DRB Project Number: PR-2024-101846 Hearing Date: 03-26-2025
4, 1, 2, 1, 3, 5, UNIVERSITY
HEIGHTS, MONTE VISTA ADDN,
located at
Project: 3200 CENTRAL AVE SE Agenda Item No: 1

Development Facilitation Team (DFT) – Review Comments

Project No: PR-2024-010846 Date: 3/26/2025 Agenda Item: #1 Zone Atlas Page: K-16

Application For: VAC-2023-00002 – VACATION OF RIGHT-OF-WAY

SITE PLAN

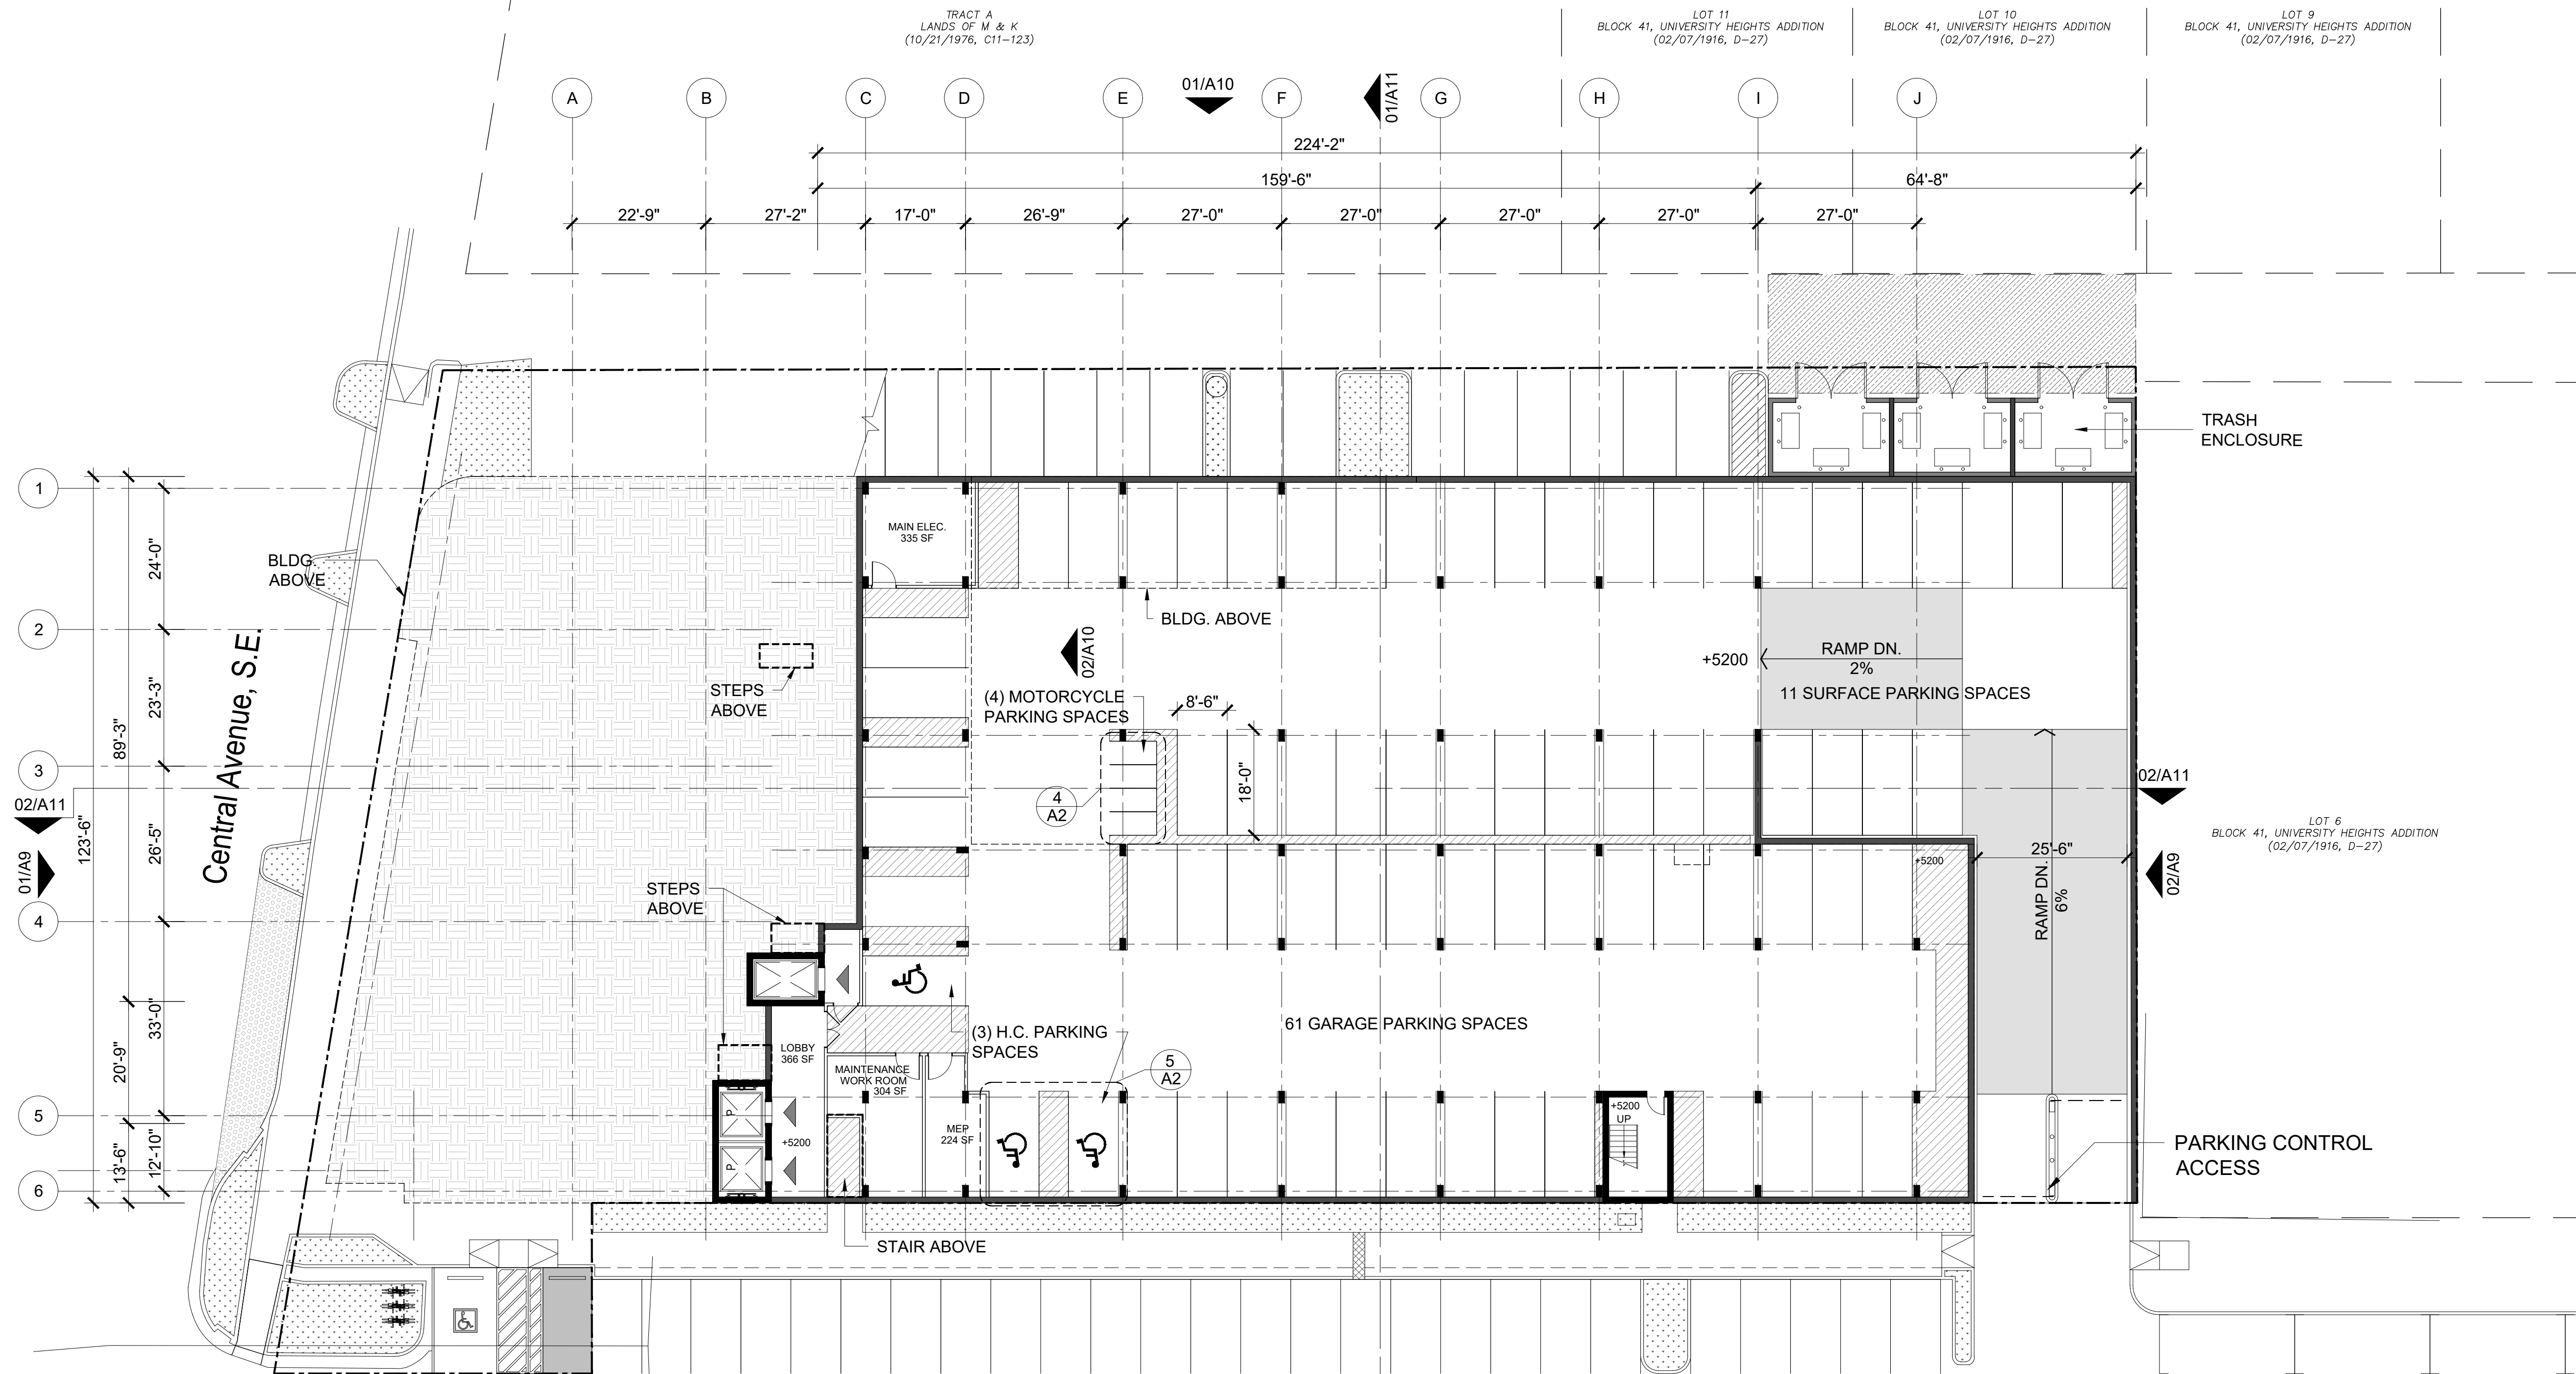
2. Central is a Main Street and requires 10' to 12' sidewalk with a 6' to 8' landscape buffer. Bryn Mawr is a local road and requires 5' sidewalk with 4' to 6' landscape buffer. Please provide a diagram with existing sidewalk and buffer widths. If you are not able to provide these widths you may request a waiver using criteria in the IDO.
3. The alleyway on the east side shows a 16' width. All alleys are required to be 20' wide. If you are unable to provide this you may request a determination with a justification letter.
4. An approved TCL will be required prior to site plan or building permit. Also, please fill out and submit a Traffic Scoping Form to determine if a traffic study will be required.

3200 CENTRAL AVE SE ALBUQUERQUE, NM		DRAWN BY pm
	HIGHWAY HOTEL MASTER UTILITY PLAN		DATE 3-26-25
	 5571 MIDWAY PARK PL NE ALBUQUERQUE, NEW MEXICO 87109 (505) 858-3100 www.tierrawestllc.com		SHEET # MU-1
	RONALD R. BOHANNAN P.E. #7868		JOB # 2024042

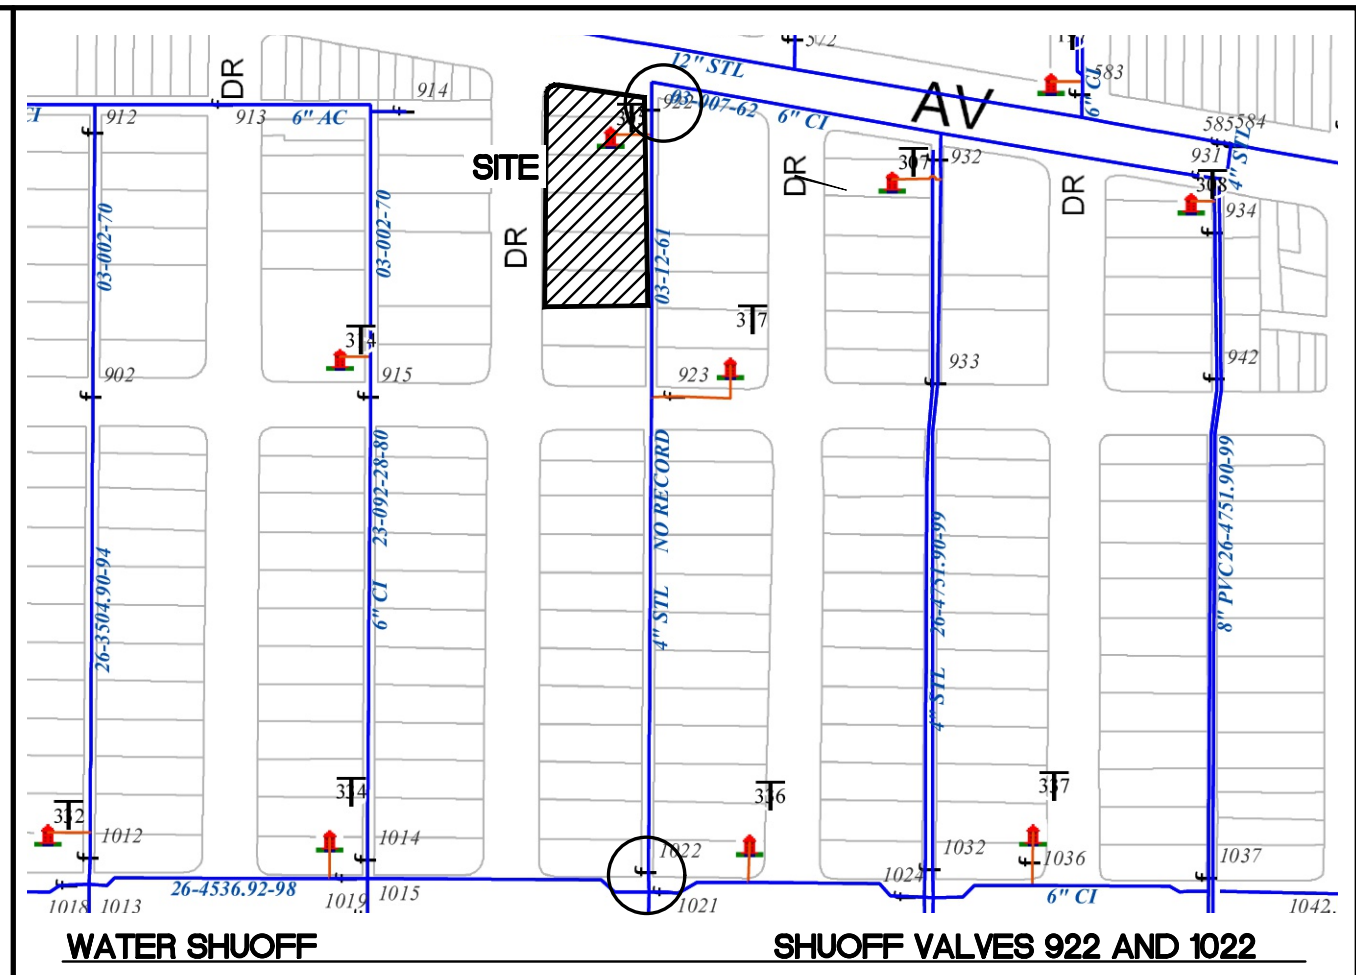
2. The southwest corner of the proposed development that previously included the stated parking area will now be taken up by a 6-inch private fire line and fire hydrant.

- a. Note this is accessible to a public roadway and any hydrants that are situated in this fashion should be public. Infrastructure improvements may be required to potentially construct a waterline along Bryn Mawr to allow this hydrant to be connection directly to a public waterline.

- b. The fire line shown to serve the fire hydrant is not clear if it is proposed as public or private.
3. Update on the Water Authority comments on the Sketch Plan:
